HINCKLEY NATIONAL RAIL FREIGHT INTERCHANGE – LAND WEST OF STONEY STANTON

COMMENTS ON APPLICANT'S RESPONSE TO SECRETARY OF STATE'S LETTER DATED 10 SEPTEMBER 2024.

Appendix A Part 1 - General Arrangement Plan

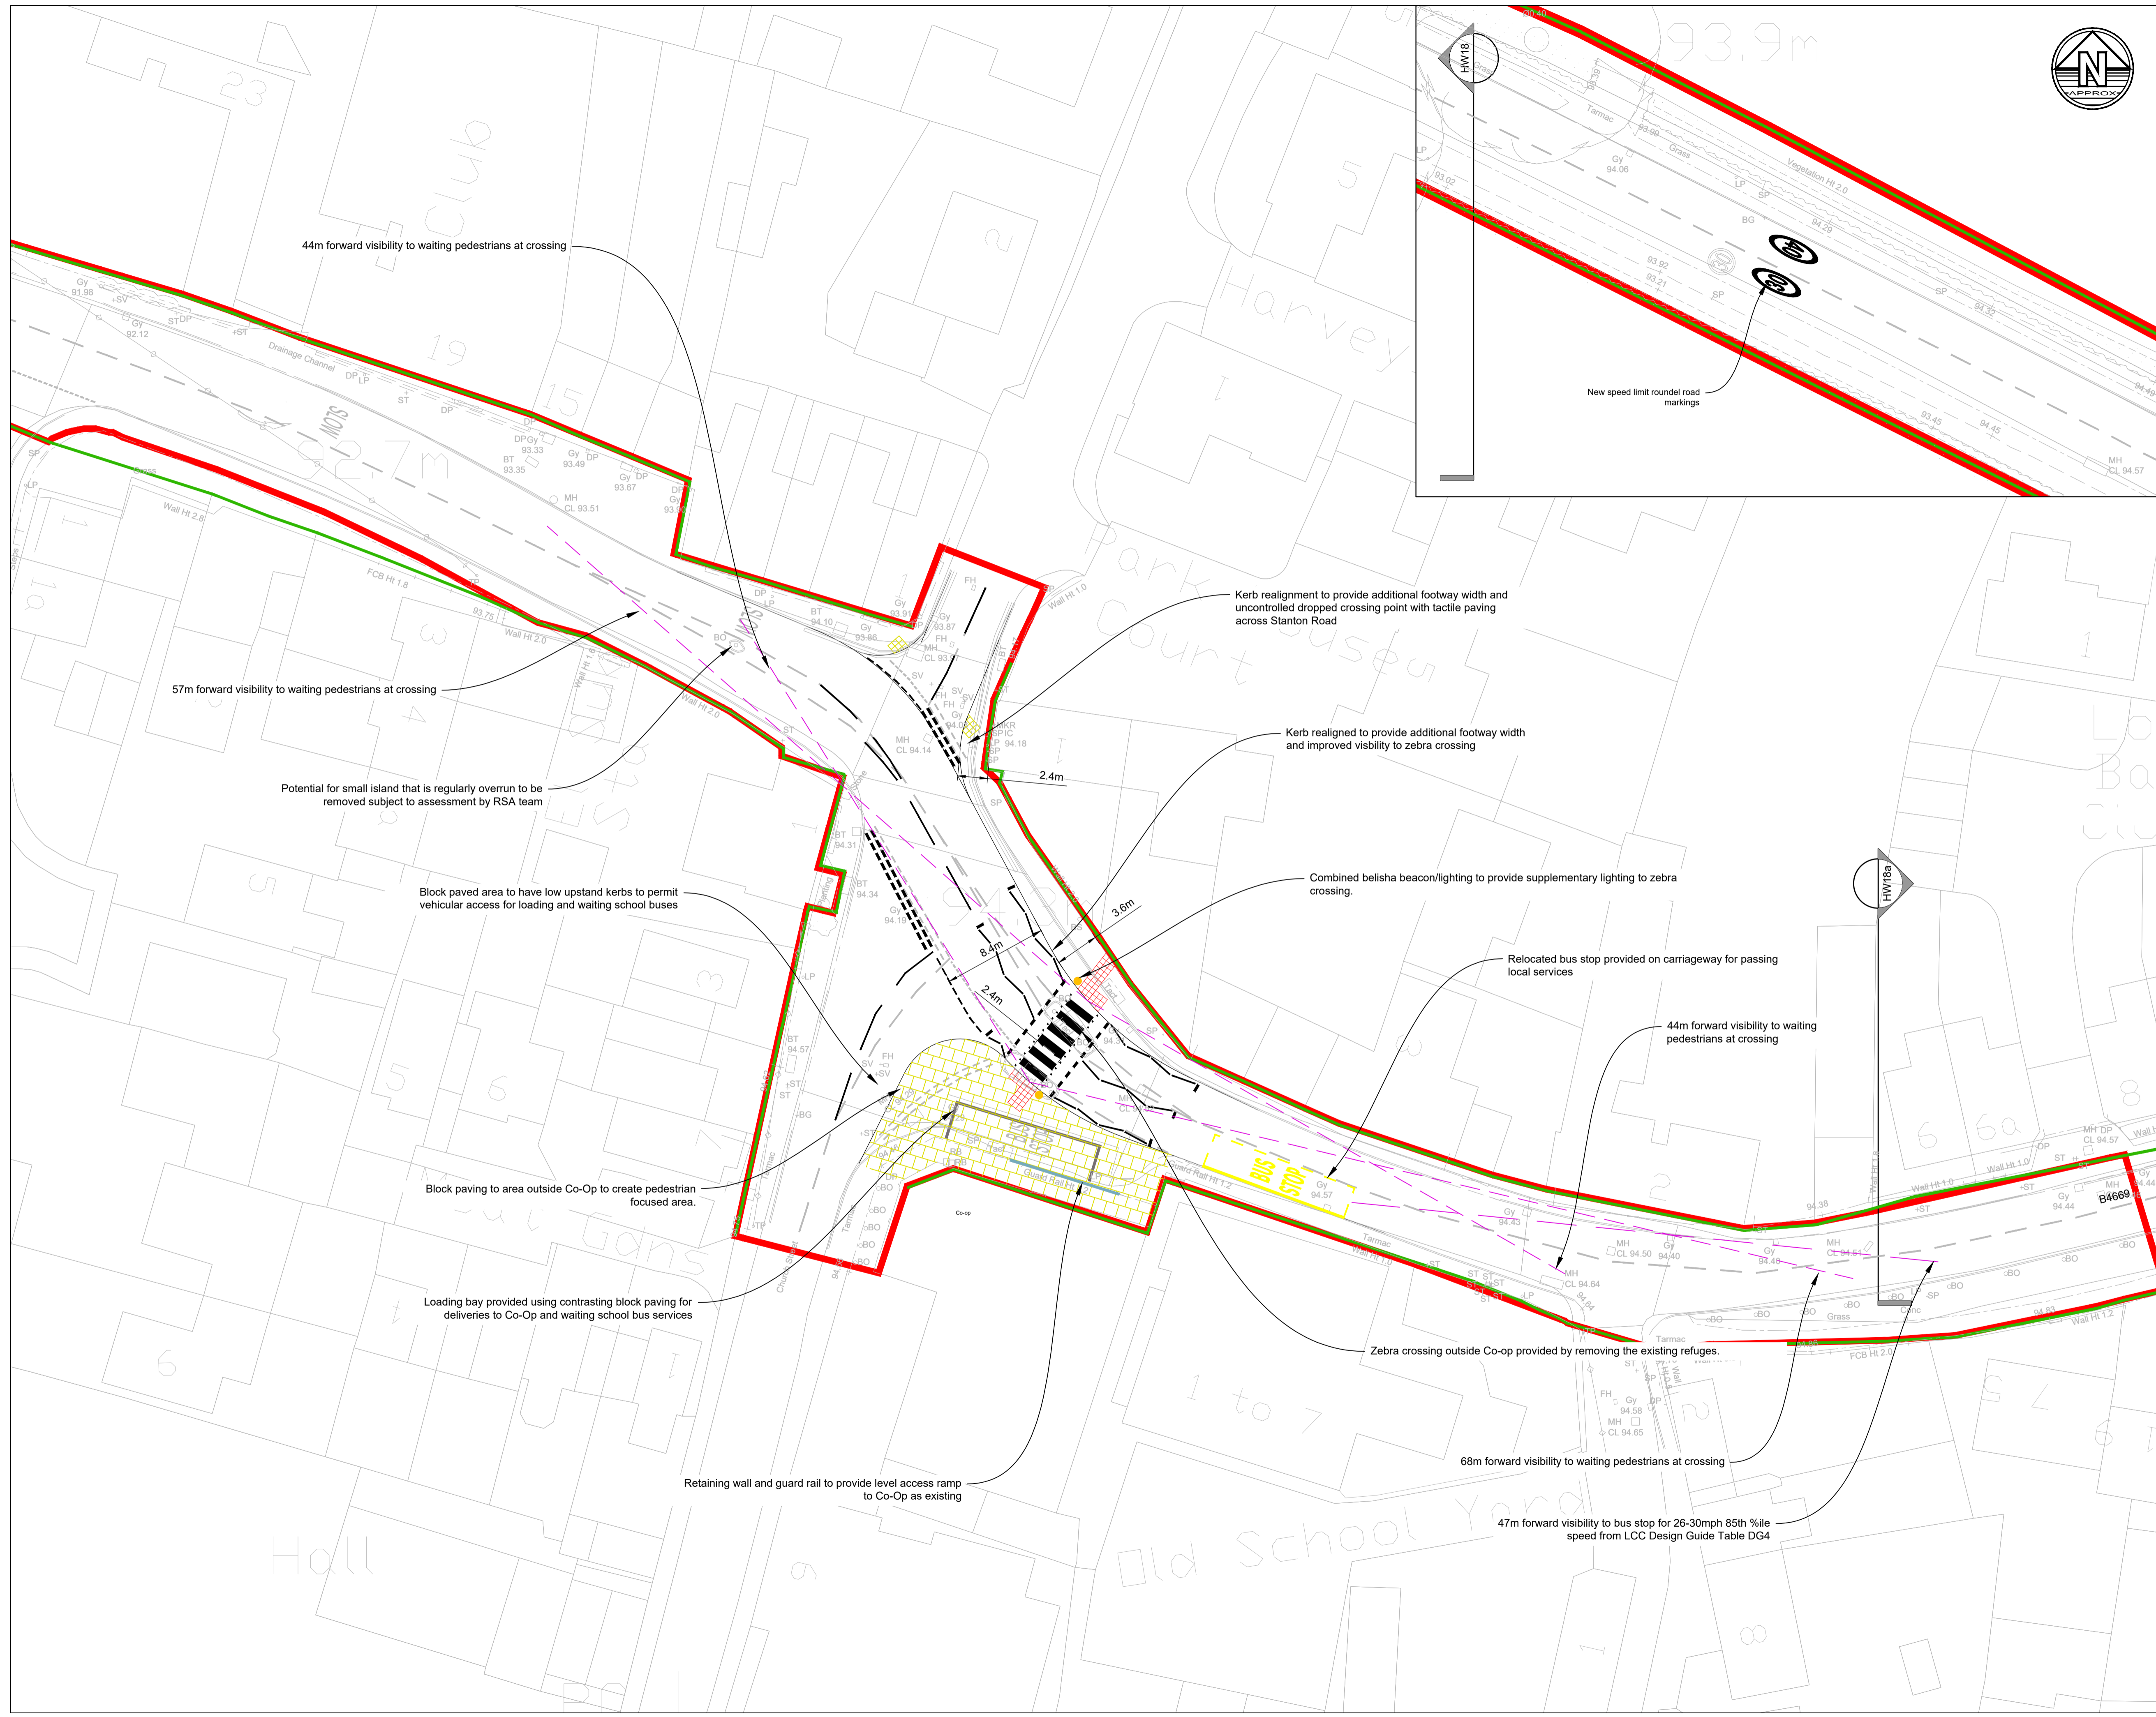
2.4. The following proposed highways mitigation works in Sapcote are minor: improvements to the pedestrian area outside the Co-Op store, delivery of a zebra crossing, additional footway widening and the re-location of the bus stop from outside the Co-Op eastwards along the B4669. These measures will not materially benefit the safety of pedestrians within the village and will not materially ease the movement of traffic through the village.
